Project # 1003127

Project Name: EAGLE RANCH SUBDIVISION

**CITY OF ALBUQUERQUE
PLANNING DEPARTMENT
Development Review Board
April 28, 2004
Comments**

Re: Vista Square/SPBP

DESIGN CRITERIA  
 Map Ref - B-12  
 Zoning - SU-1  
 Site Area - 1.015 Acres  
 Occupancy - B

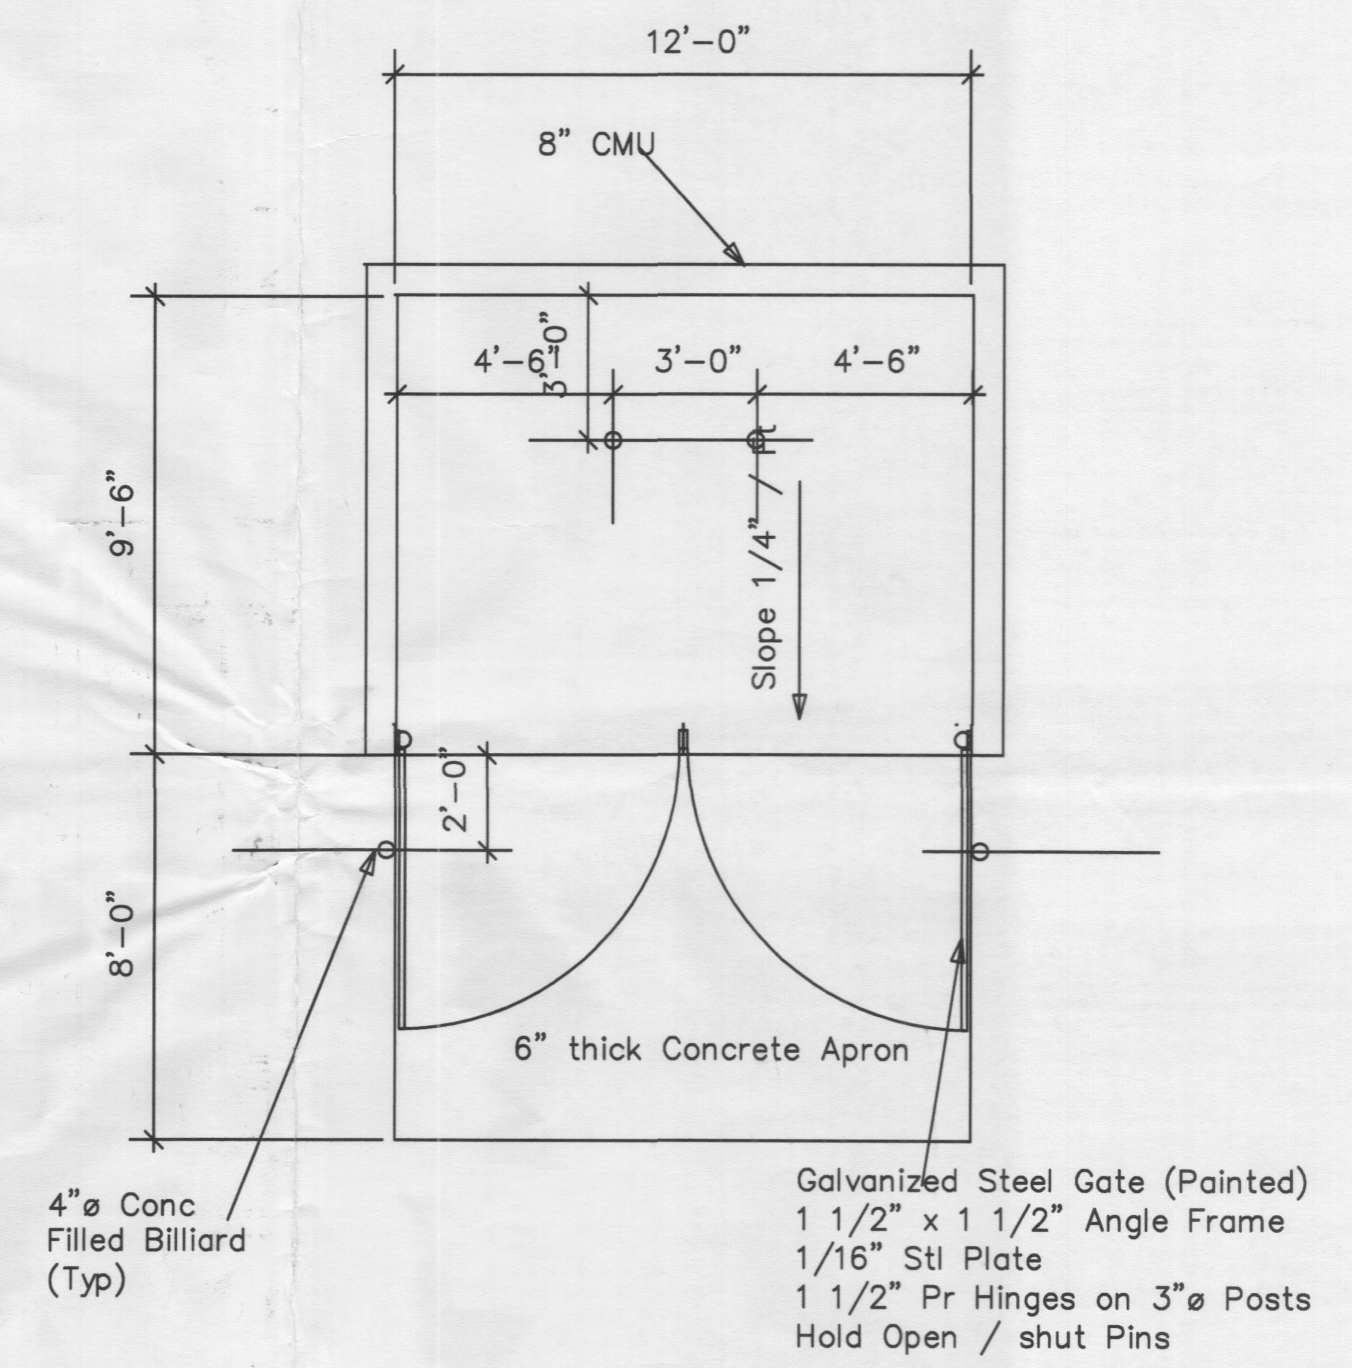
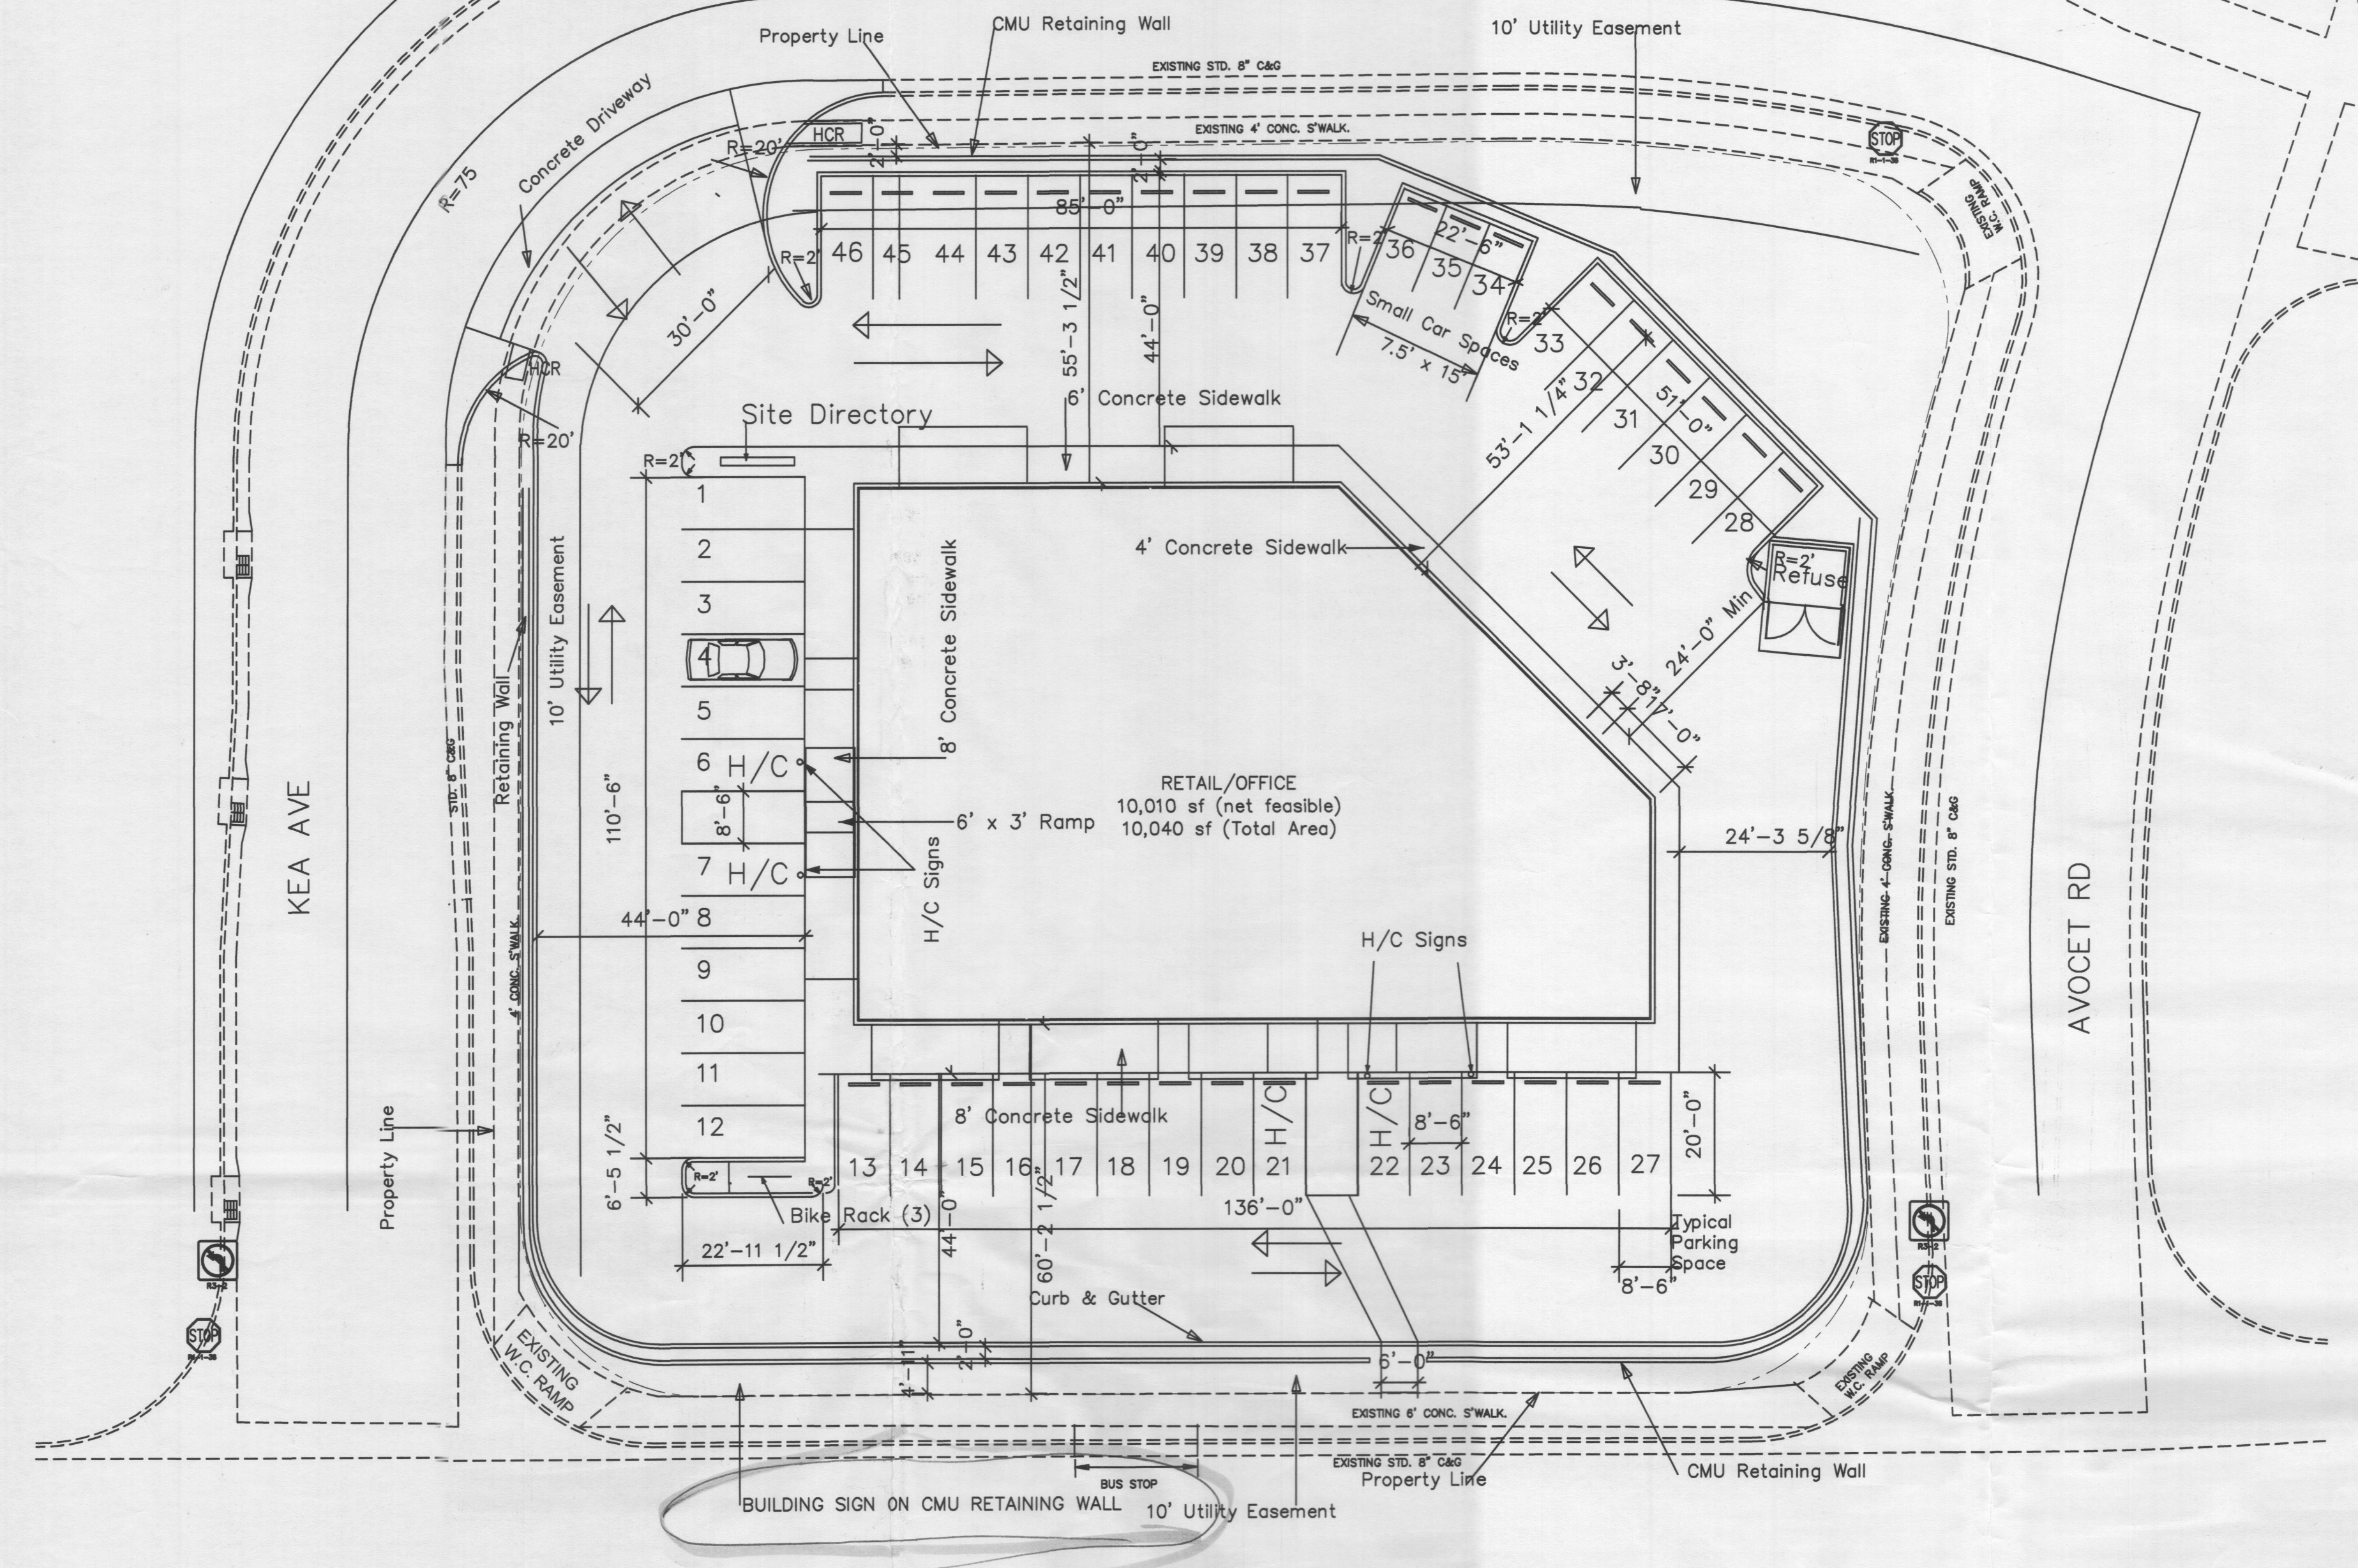
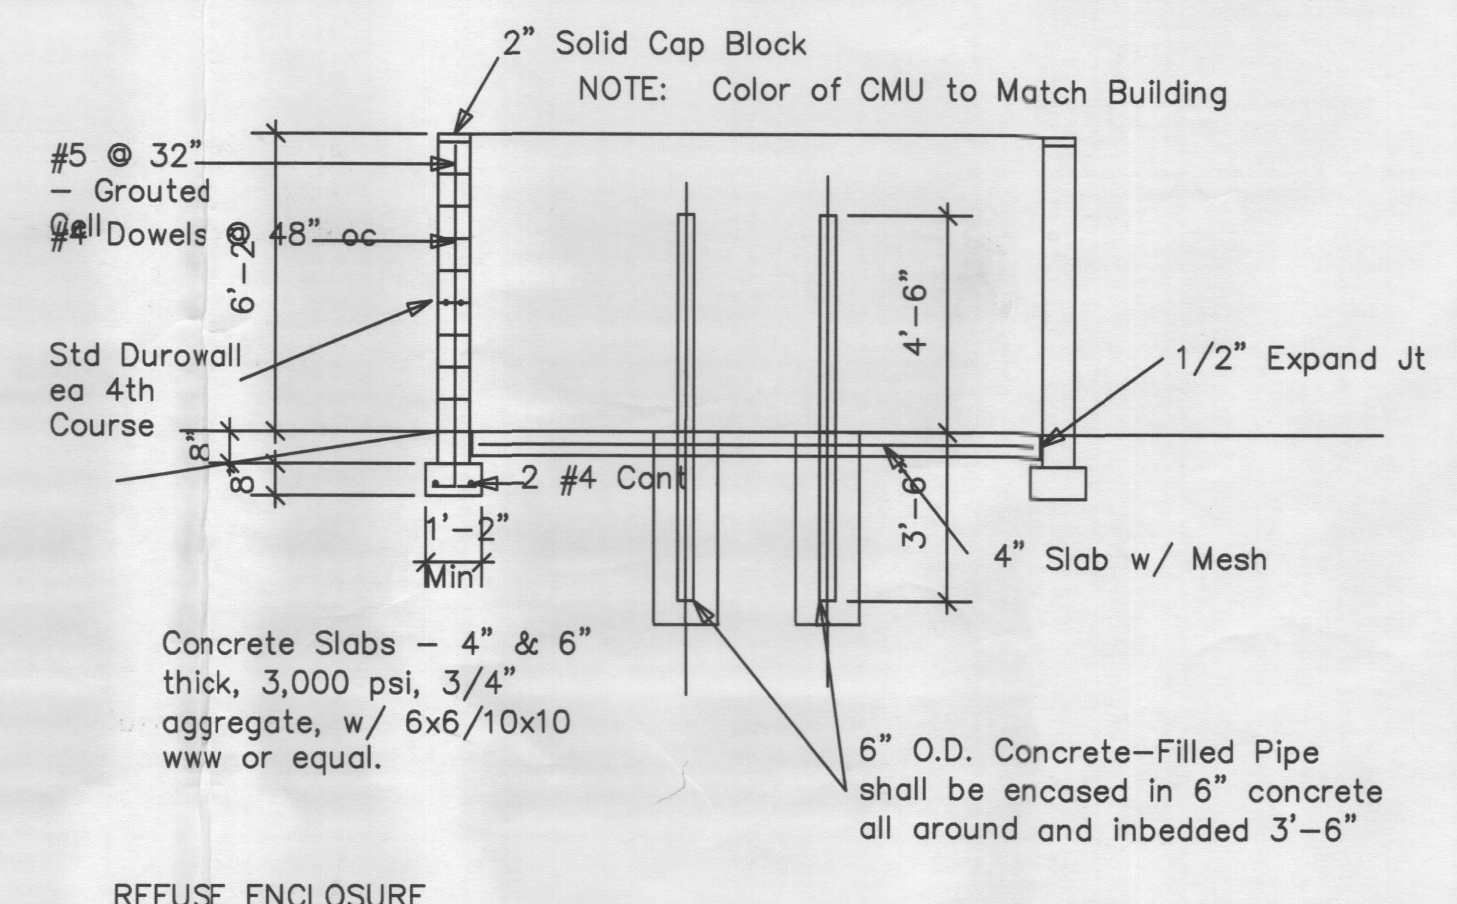
? Project # & App # need on site plan sheet

✓ The Site Plan for Building Permit signature block is missing a short paragraph pertaining to whether an infrastructure list is required for this plan or not. Even if there is no infrastructure required, the paragraph is required.

✓ Under Design Criteria on the site plan sheet, the zoning is listed as SU1. It is actually SU1 for C1. Please correct.

✓ The property line on the site plan & landscaping sheets should be bold so that is obvious. There are several lines, etc in the vicinity of the property lines making it hard to distinguish where the property line actually is.

The site plan for subdivision approved in 1996 has language related to mechanical equipment screening which should be placed on the SPBP sheet: "All mechanical equipment will be screened from view of the adjacent parking area and public right of way. In addition, if it is determined that the mechanical unit can be observed from the residential area east of this project, screening is required".

**LANDSCAPING PLAN**  
**"VITA SQUARE"**  
 10200 Golf Course Rd NW, Albuquerque, NM  
**BILL BURK, THIRD, ARCHITECT**  
 #03-18 12/31/03

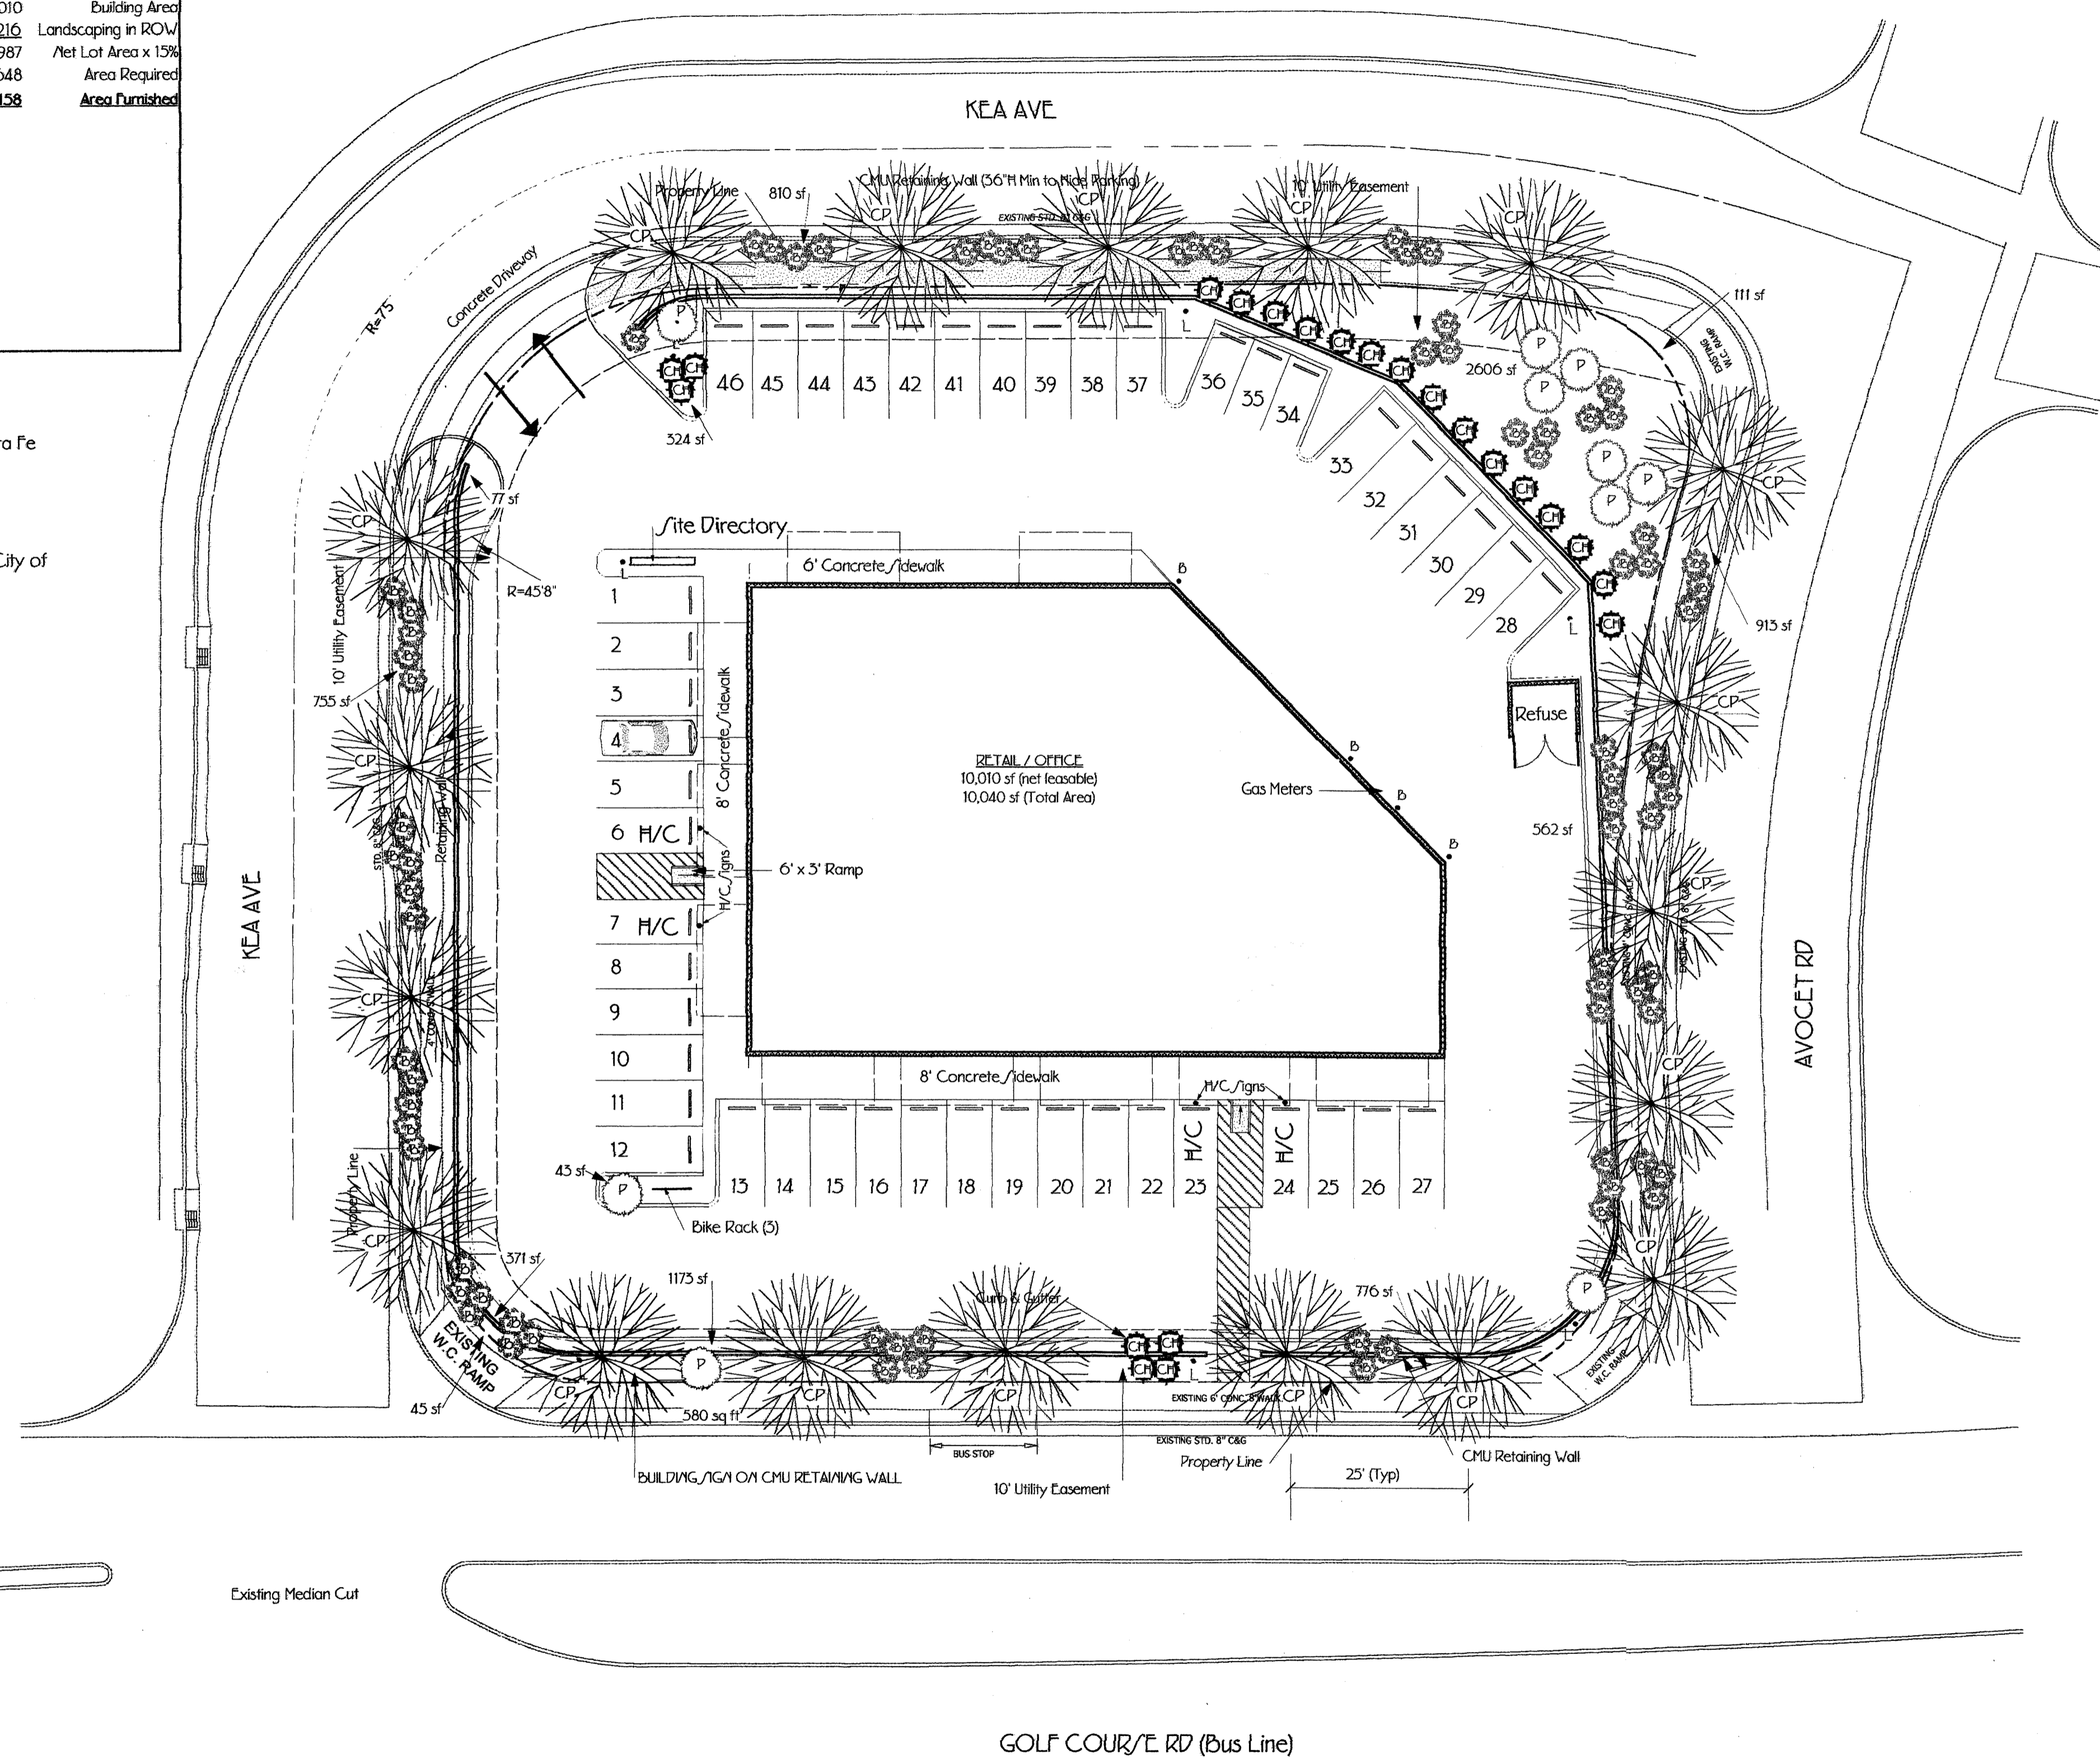
- ✓ The junipers should be removed from the landscaping plan as they are a high allergen plant. Rosemary is one possible substitute.
- ✓ The water usage (H,M,L) should be indicated for each plant.
- ✓ There are specific statements to be added to this sheet regarding #11 & 12 of the SPBP Checklist.
